**Application for Planning Permission for Works or Extension to a Dwelling**

**Development** 2 no. new windows to west elevation

**Location** 12 Chawkmare Coppice Bognor Regis,,

24th May 2012

LOCATION PLAN. [1:1250]

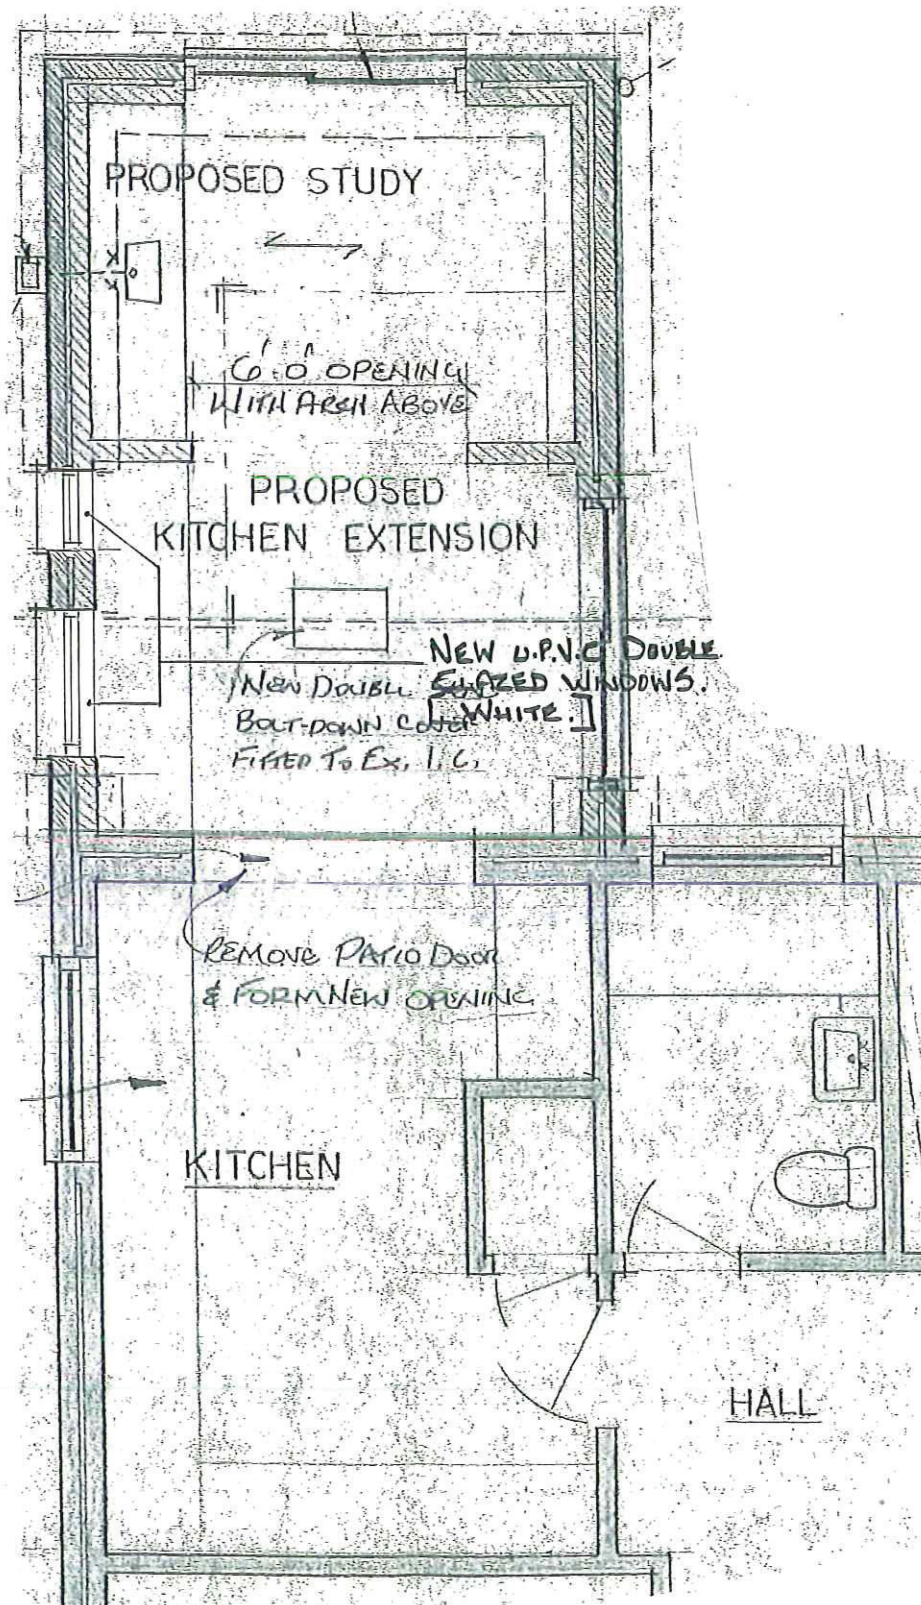
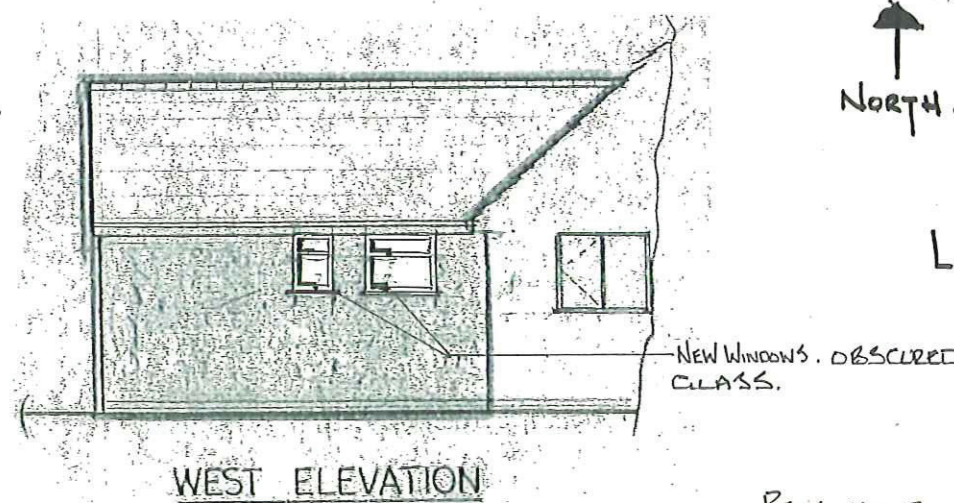
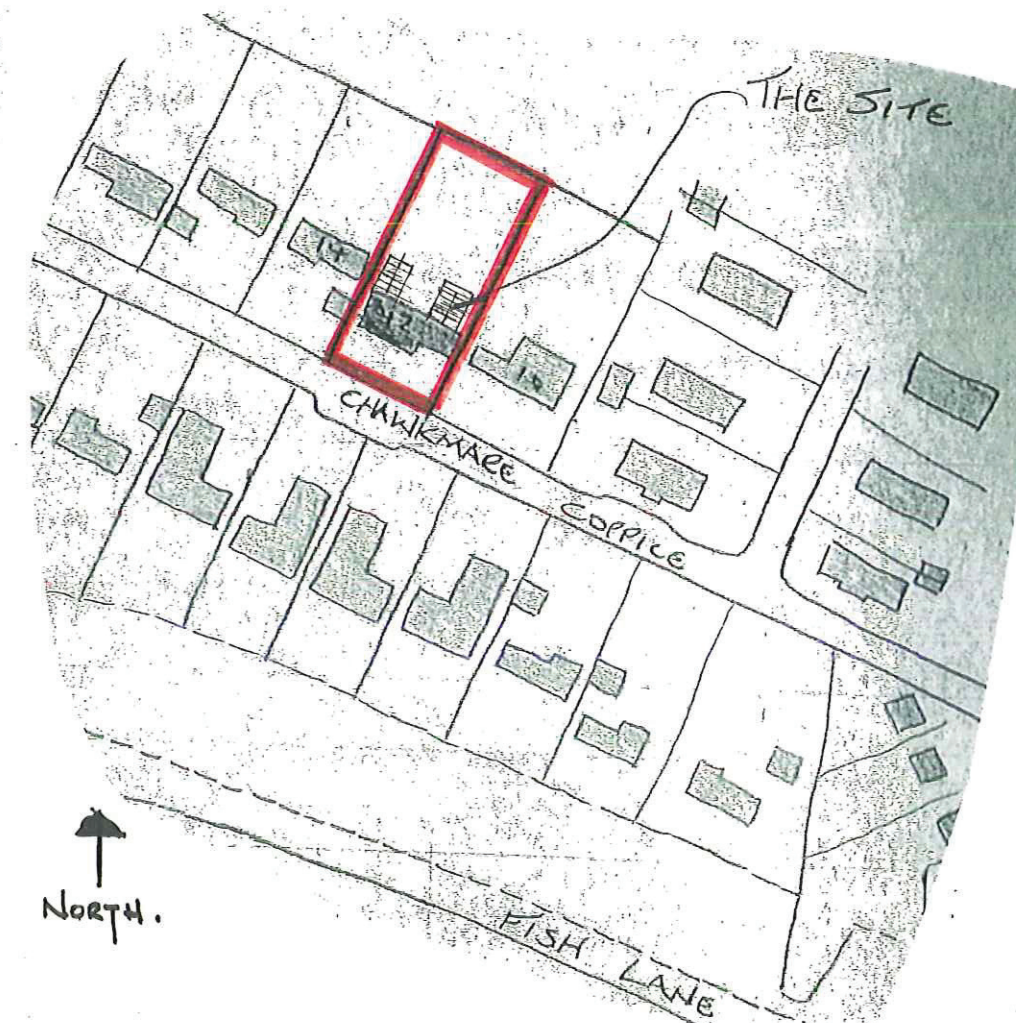
I require 1 electronic or 3 paper copies of a revised block/site plan. The plan provided needs to show a north point and appears to show a new extension which is not included in the description. Please clarify and amend accordingly.

I require 1 electronic or 3 paper copies of a revised location plan. The plan provided does not accord with the site plan (extension shown on site plan which are not detailed on location plan) and needs to show a north point. Please amend.
